7 August 2019

**Subject: State Significant Development (ssd 8753) - Concrush Teralba
Lake Macquarie City Council reply to Response to Submissions
prepared by Umwelt.**

Thank you for the opportunity to comment on the Environmental Impact Statement (EIS) for the expansion of the Concrush Resource Recovery Facility, Teralba.

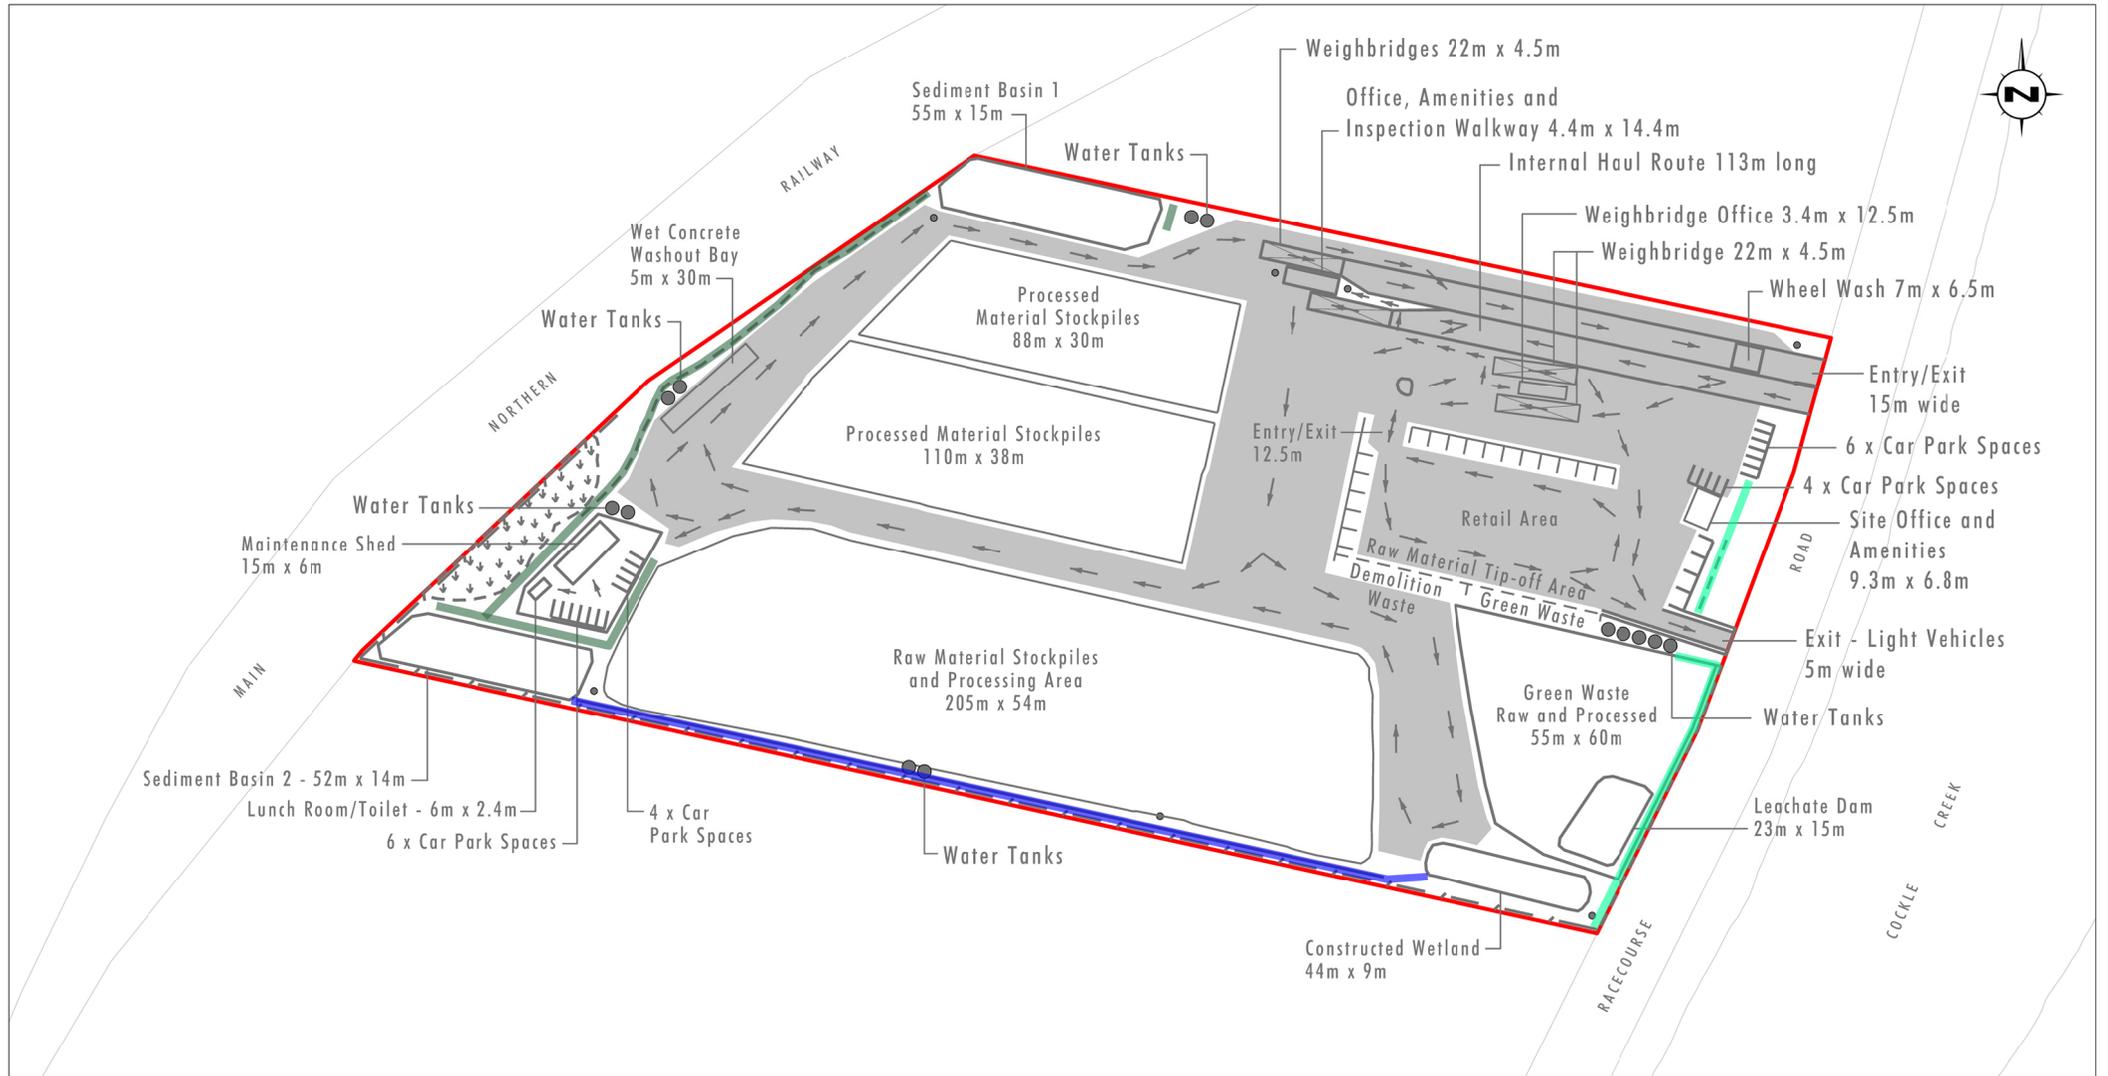
Council has reviewed the response provided and consider that additional landscape plantings proposed will aim to screen the views from the site from all boundaries. The width of the planting area will vary due to site constraints and use only endemic species that are floristically diverse. This approach is supported, thus the following condition is recommended for determination:

The landscape bund along the Racecourse Road frontage is to remain landscaped with additional landscape works including the planting of endemic trees, shrubs and ground covers to ensure a continuous landscaped screen along the entire roadway frontage.

The south western corner of the site is to retain existing endemic site vegetation and include supplementary landscape works that include revegetation that enhances habitat opportunities using the planting of endemic vegetation.

The southern boundary is to incorporate tree, shrub and ground cover planting where possible to integrate with the stormwater management of the site and provide vegetative screening of any concrete block walling.

All plantings are to be representative of the ecological and scenic values of the surrounding Lake Macquarie lakeside landscape character and be designed to minimise the visual impacts of the proposed works when viewed from any of the surrounding lands.

#### DETAIL PLAN

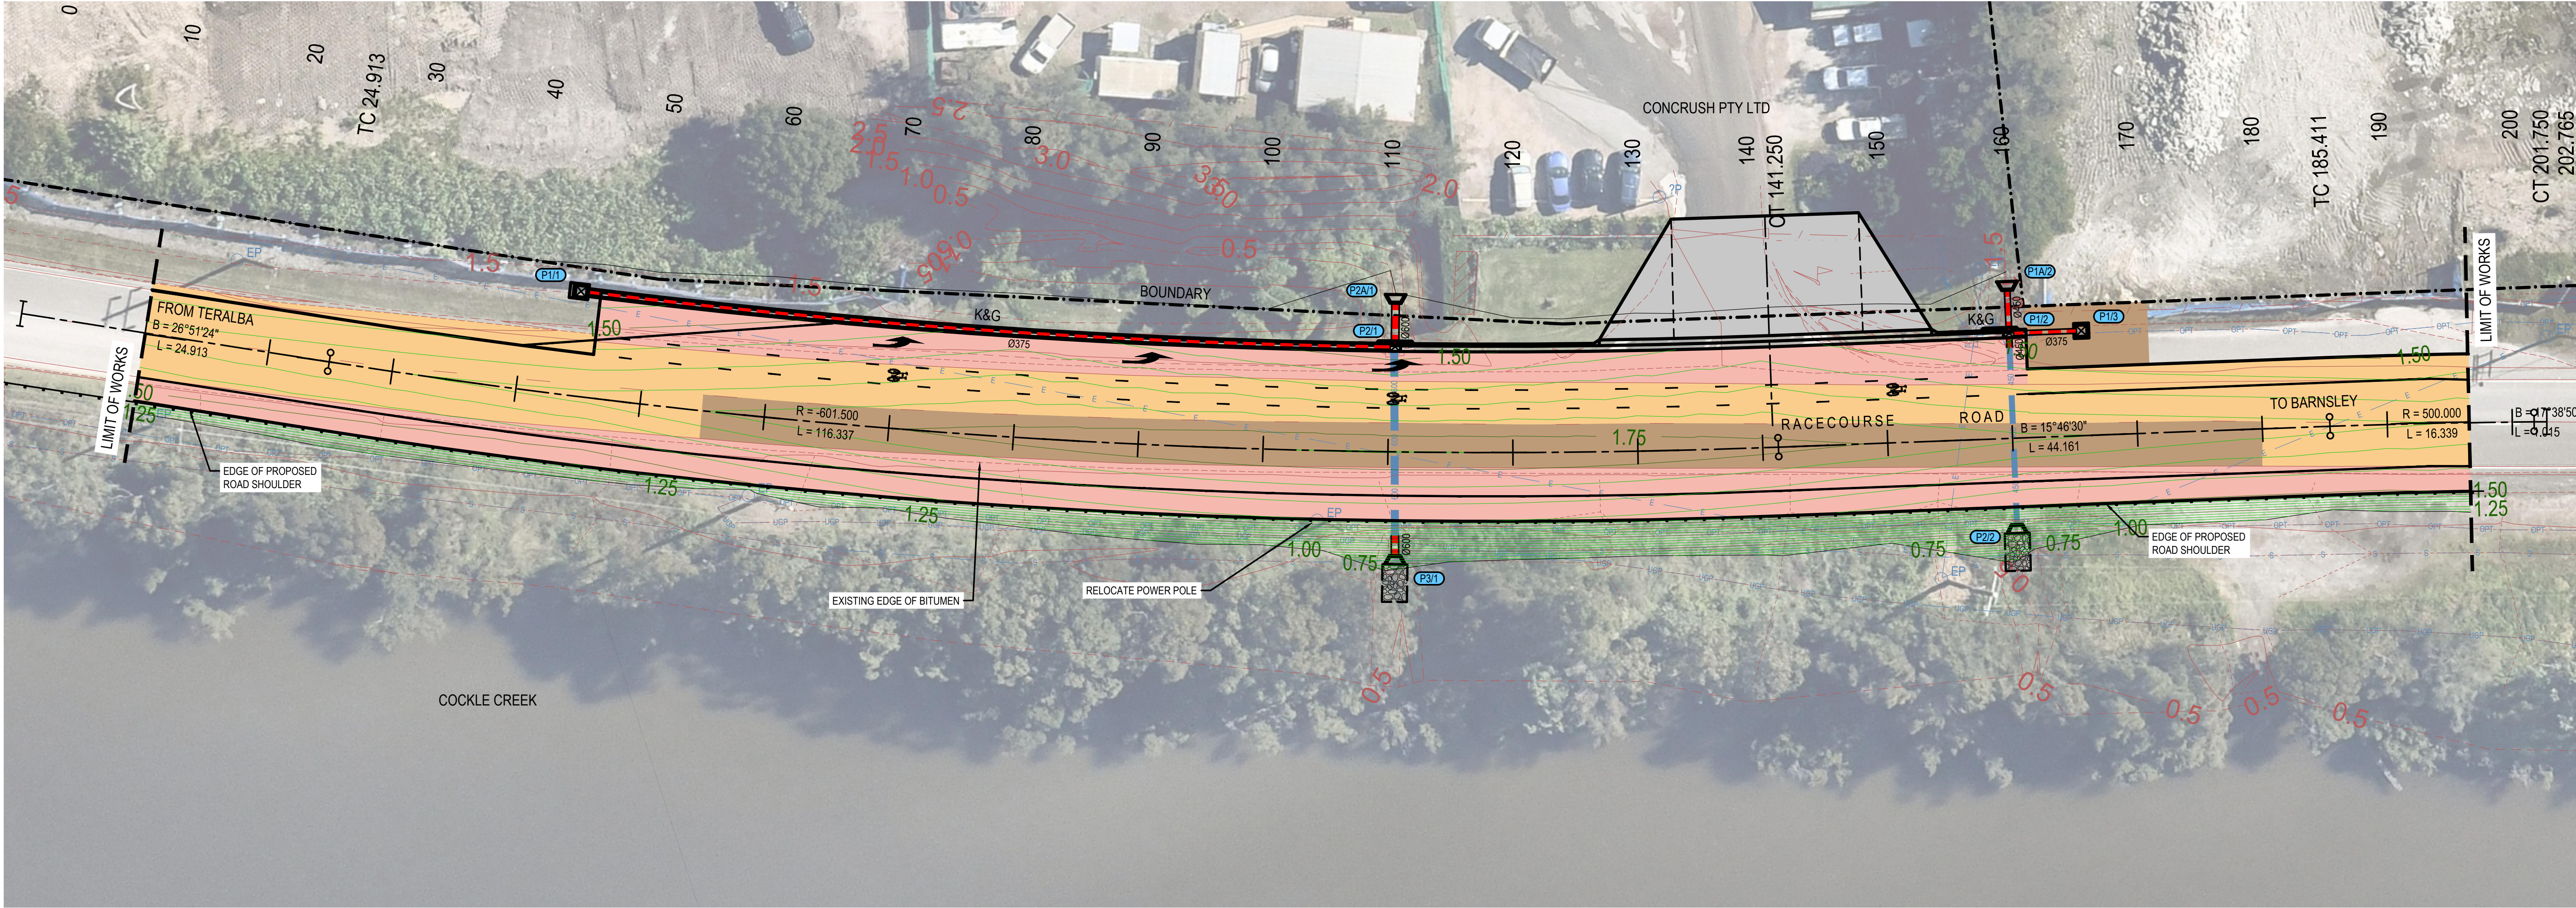
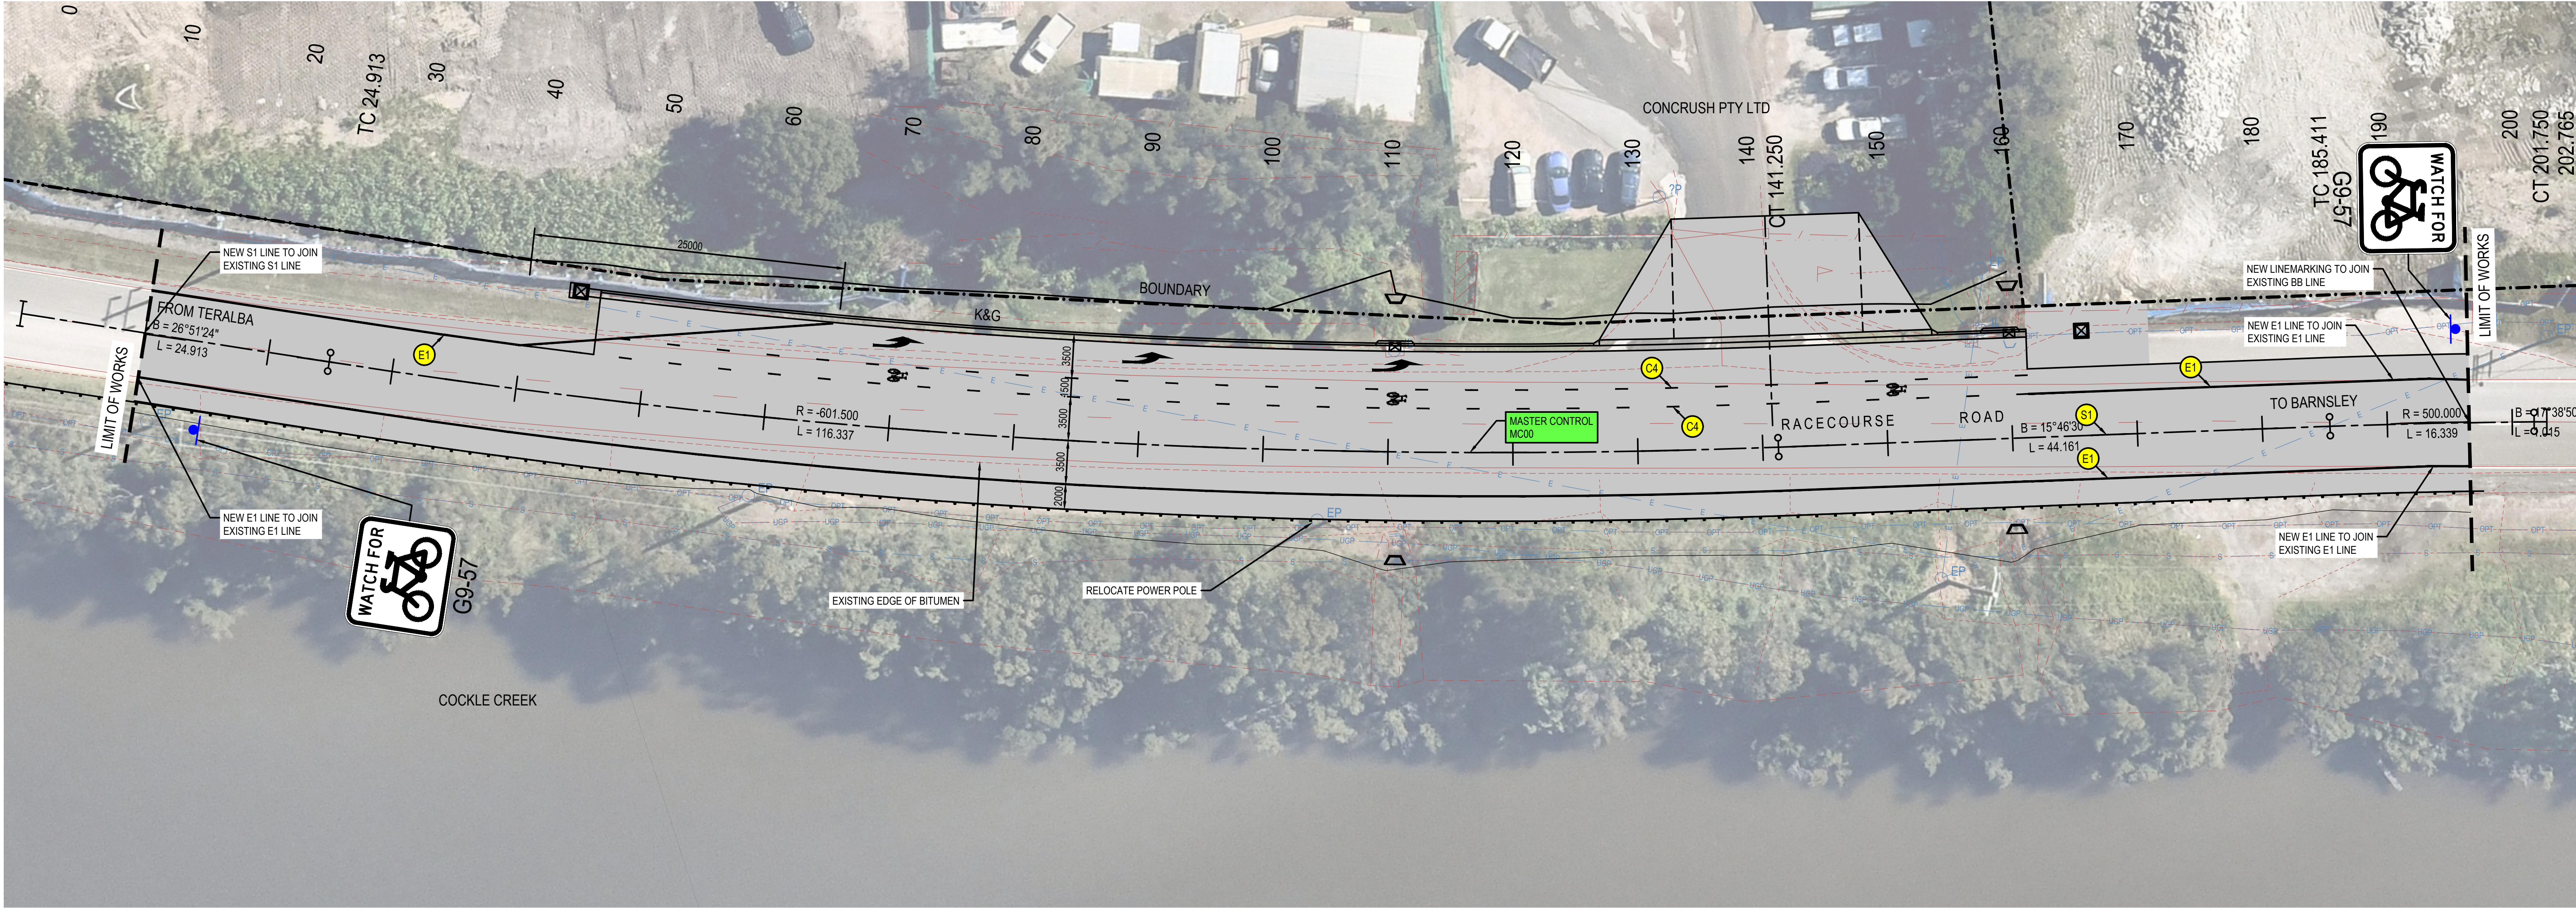
- An AUL(s) left turn treatment is adequate.
- A BAR right turn treatment is adequate.
- On road cycling lanes are to be provided in both directions on Racecourse Rd through the intersection.
- These are to be designed to Austroads Guidelines.
- These treatments are subject to LMCC Traffic Facilities and Road Safety Committee endorsement and Council approval. The approval process could take up to three months and must be finalised and installed prior to Occupation Certificate.

All regulatory line marking and works on Public roads shall be submitted to Council's Traffic Facilities & Road Safety Committee. Works on line marking and road design shall not commence until approved by the Committee.
